Recommendation Report for Planning Permission for Works or Extension to a Dwelling

REF NO: AW/92/20/HH

LOCATION: 47 West Drive
Aldwick
PO21 4LZ

PROPOSAL: Part two storey part single storey side and porch to front.

PROPOSED FIRST FLOOR & ROOF PLAN

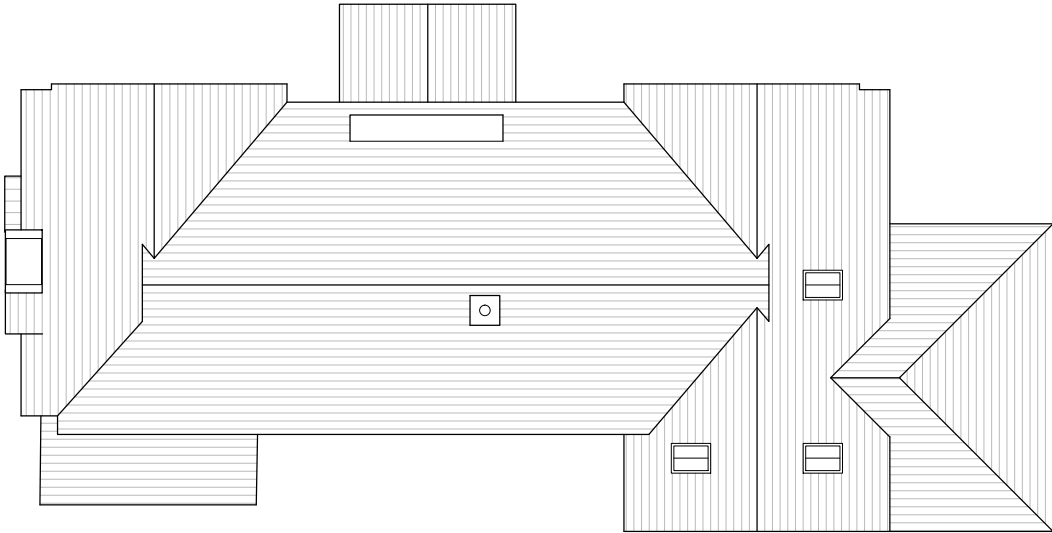
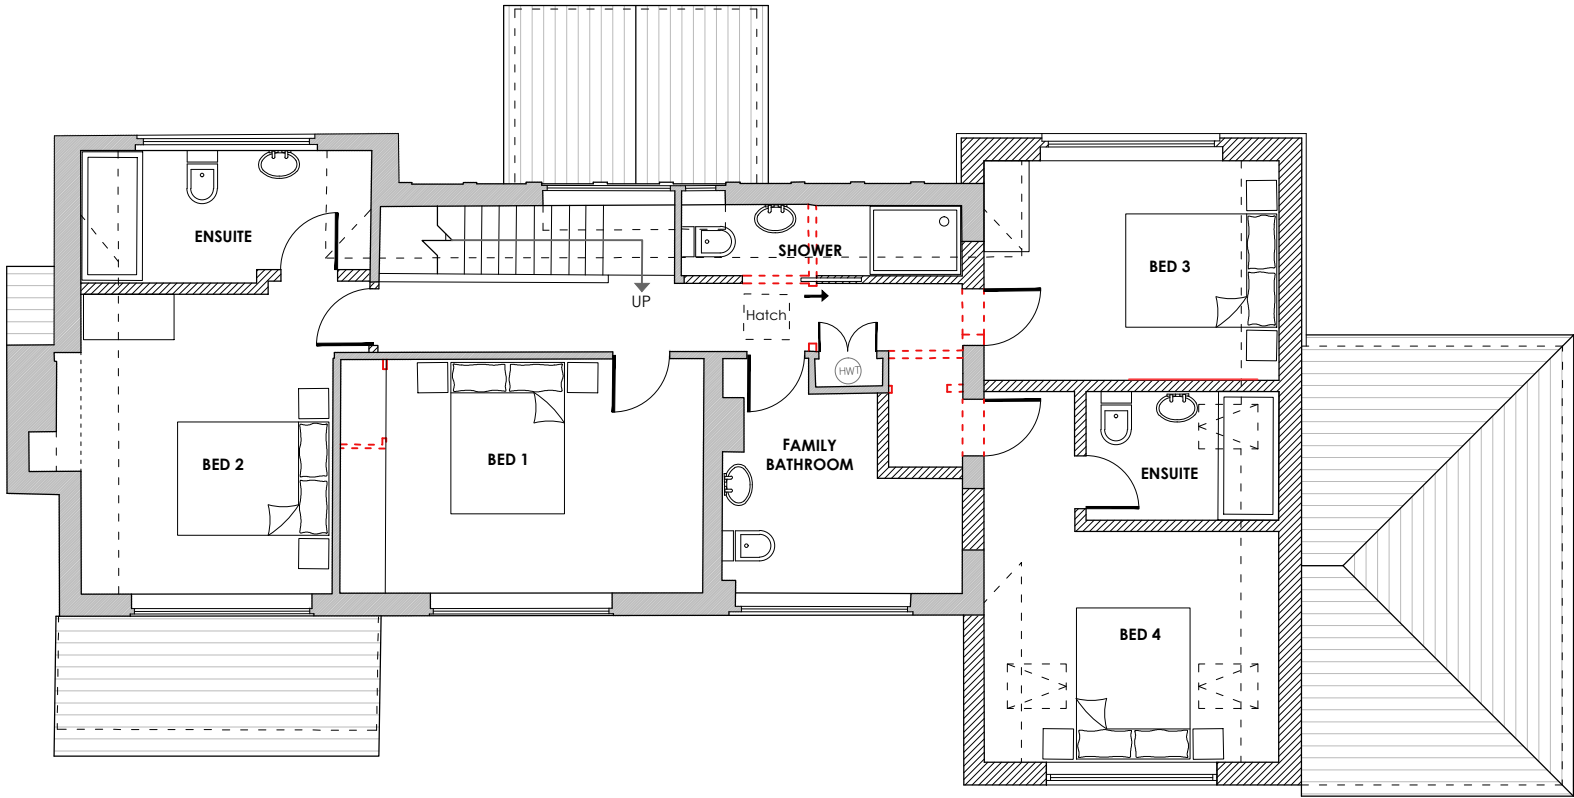
Additional ground floor windows are not considered to result in adverse overlooking. There will be an additional first floor window which projects beyond the existing rear facing elevation, with only 4m retained to the rear boundary. This has been reduced in size such that due its height above finished floor level is not considered to result in significant overlooking with sufficient boundary treatment in place. 2 velux are to be installed to the east and west elevations. However due to their siting are not considered to provide adverse overlooking.

- 3 No windows (other than those shown on the plans hereby approved) shall be constructed above ground floor level in the south elevation of the extension hereby permitted without the prior permission of the Local Planning Authority on an application in that behalf.
